Application for a non-material amendment following a grant of planning permission.

Demolition of 1 No. existing house & grounds & erection of 2 No. new detached dwellings. This application may affect the character & appearance of the Station Road, East Preston Conservation Area.
--

Reference number:	R/190/18/PL
-------------------	-------------

change in roof detail of the side dormer from a flat roof to a hipped roof no higher than 1m more than the flat roof version.

Drawing Title:
ADDITIONAL DWELLING
PLOT 1
ELEVATIONS

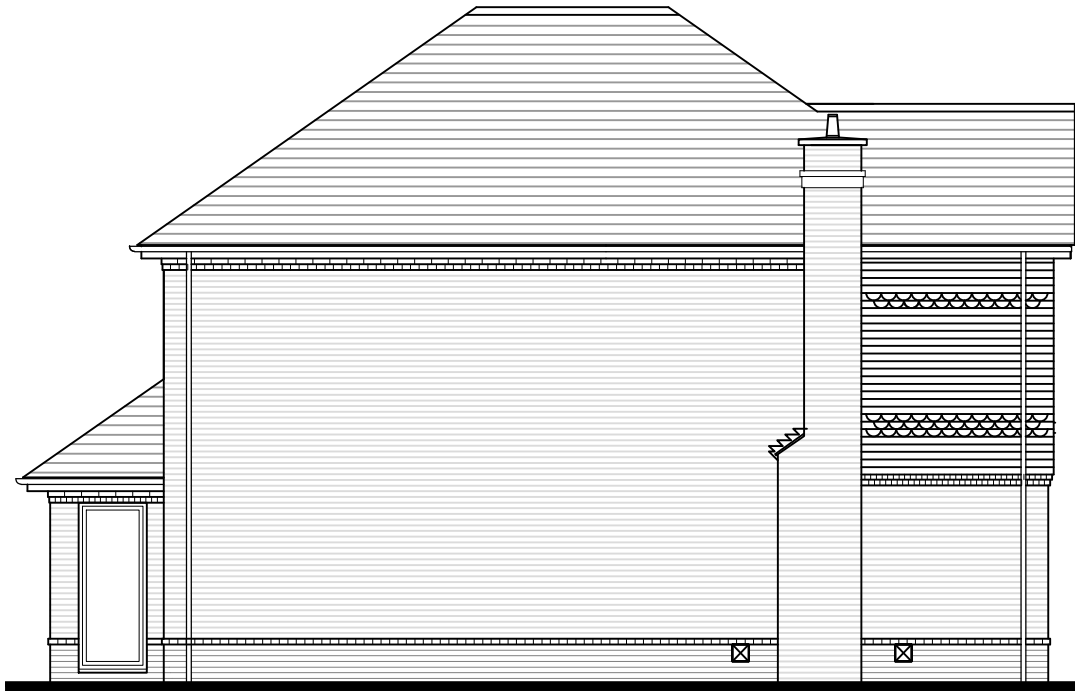
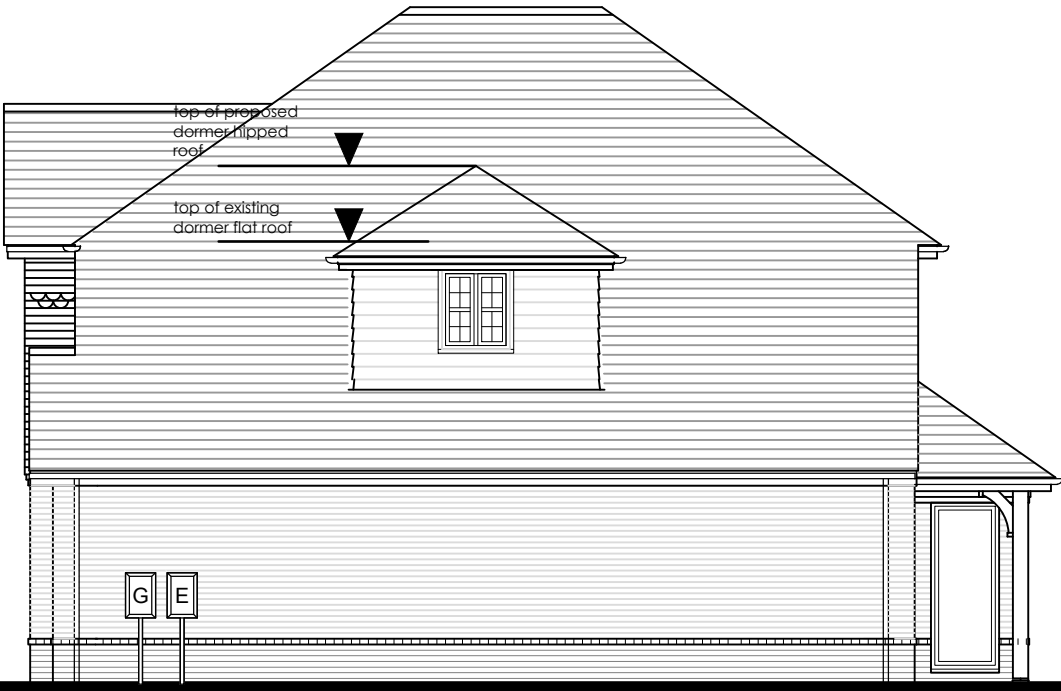
to avoid flat roof detailing

change is acceptable subject to not exceeding 1m height restriction mentioned above.
